SUBJECT: Project 35993.1.1 (U-4700) Caldwell, Catawba, and Burke Counties

Proposed US 321 Widening from US 70 in Hickory to Southwest Boulevard in Lenoir

Post Combined Public Hearing Meeting Summary

GRACE CHAPEL RD. ALTERNATE DESIGN 1 - SUPER STREET

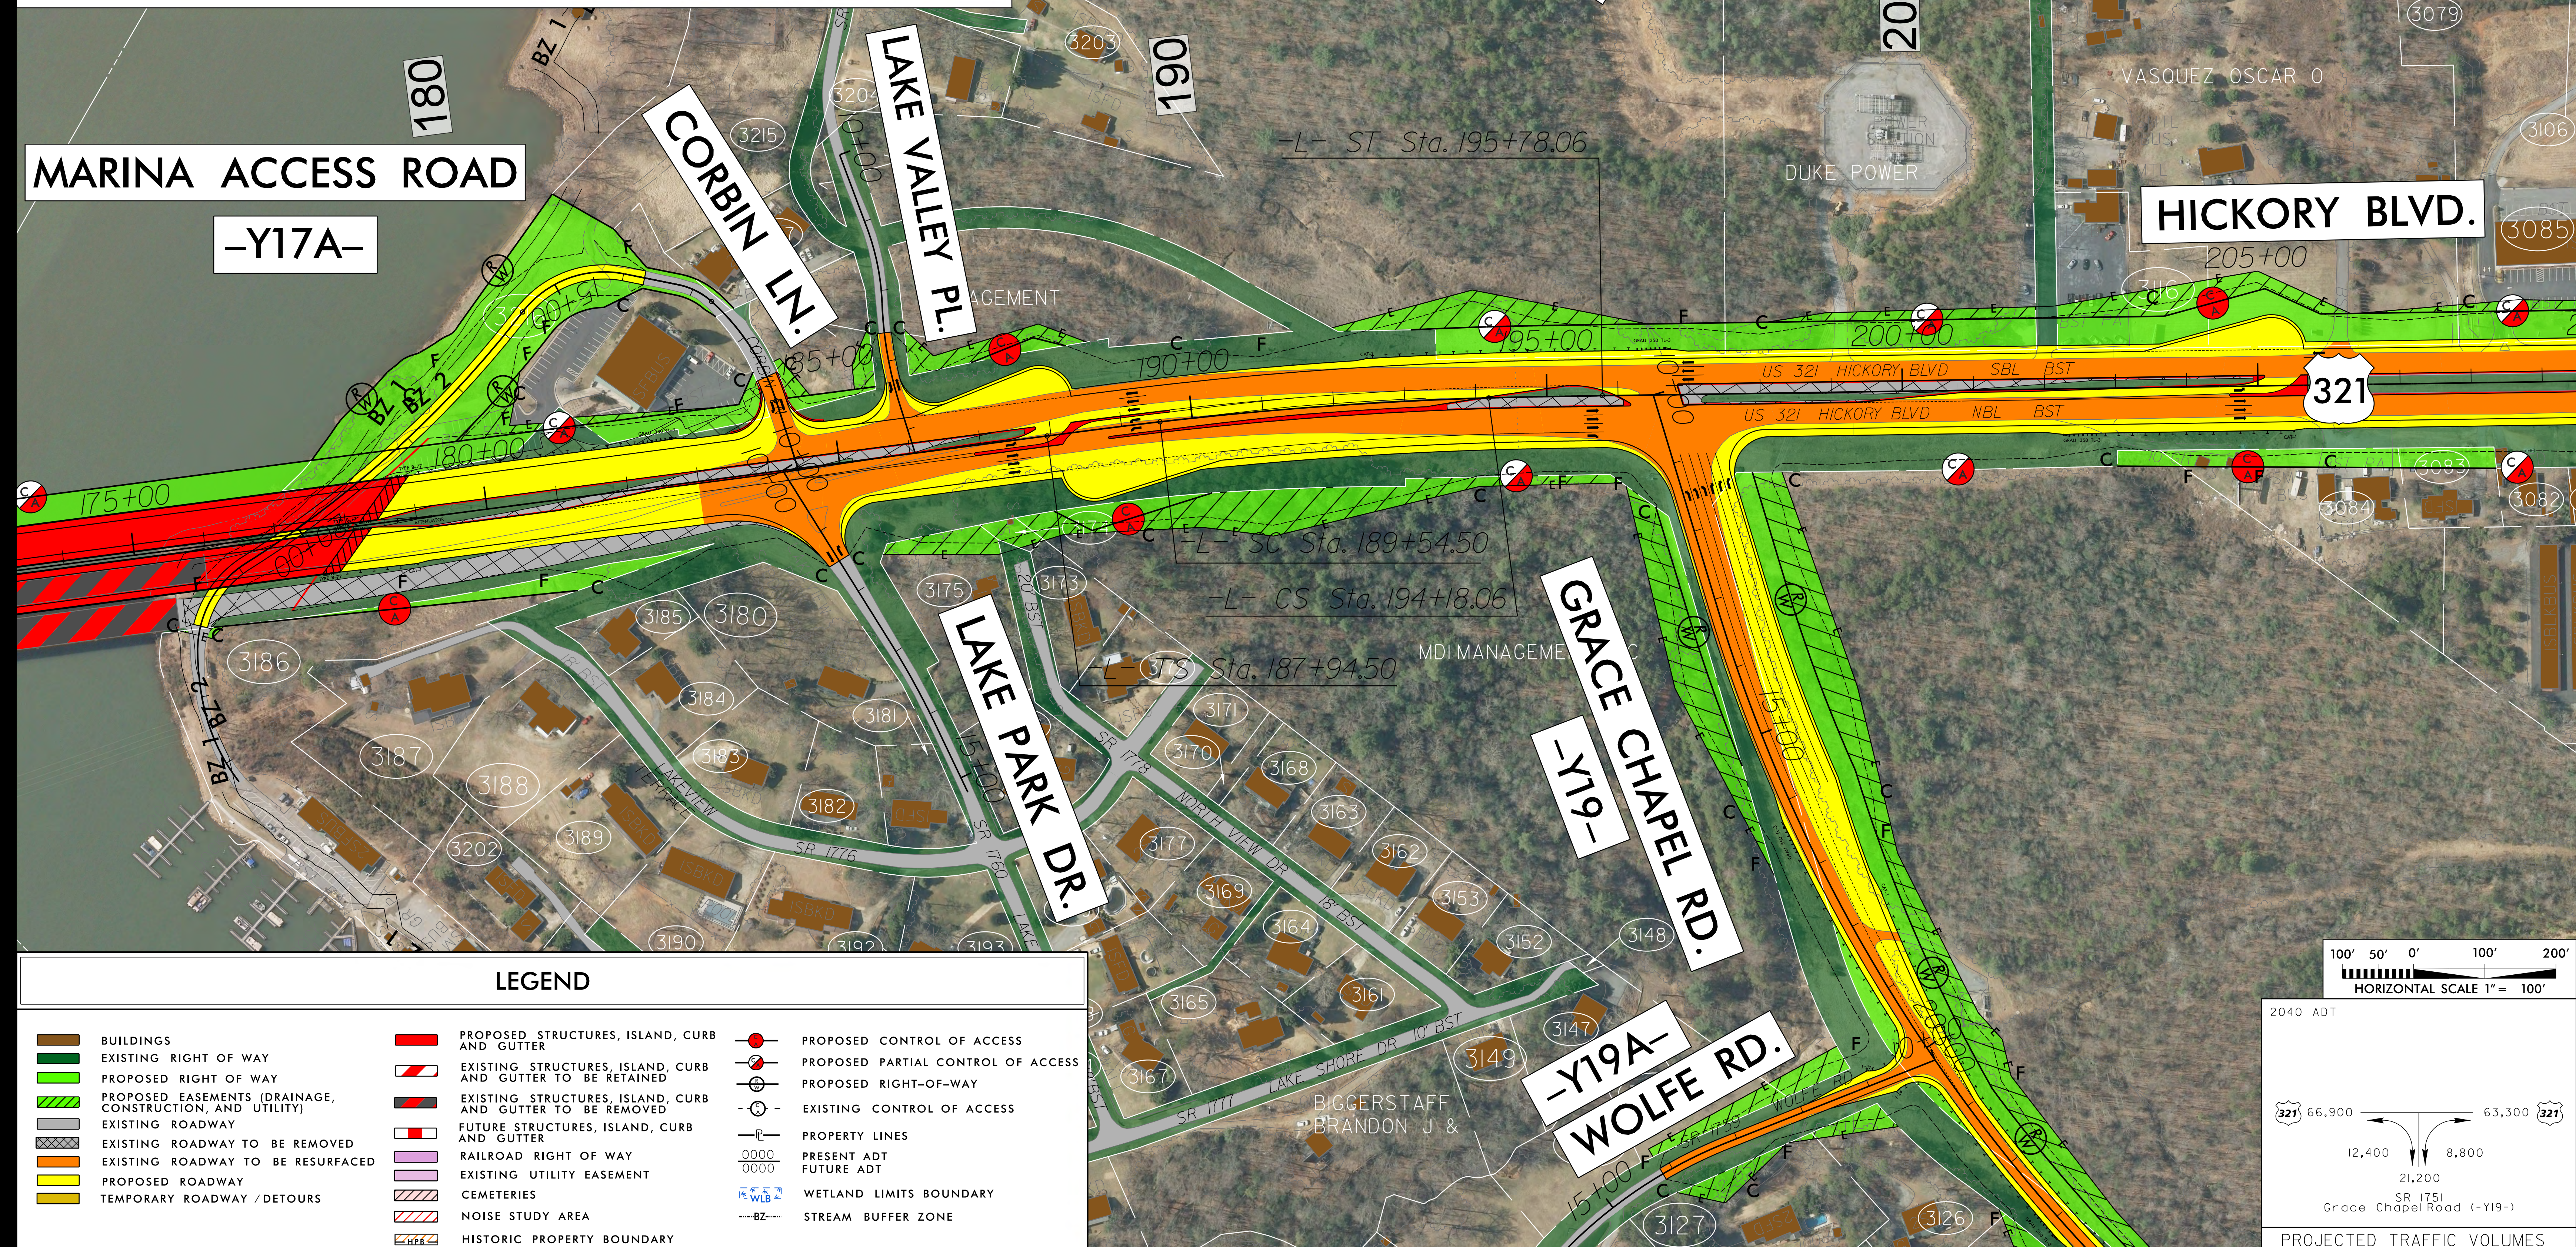
Comment: Mr. Richardson is concerned about a superstreet design at Falls Avenue, particularly for tractor trailers from MDI. He asked if Falls Avenue will be lowered or if US 321 will be raised for the superstreet alternative.

Response: The Falls Avenue superstreet alternative, which is an at-grade design, would lower Falls Avenue to the grade of US 321.
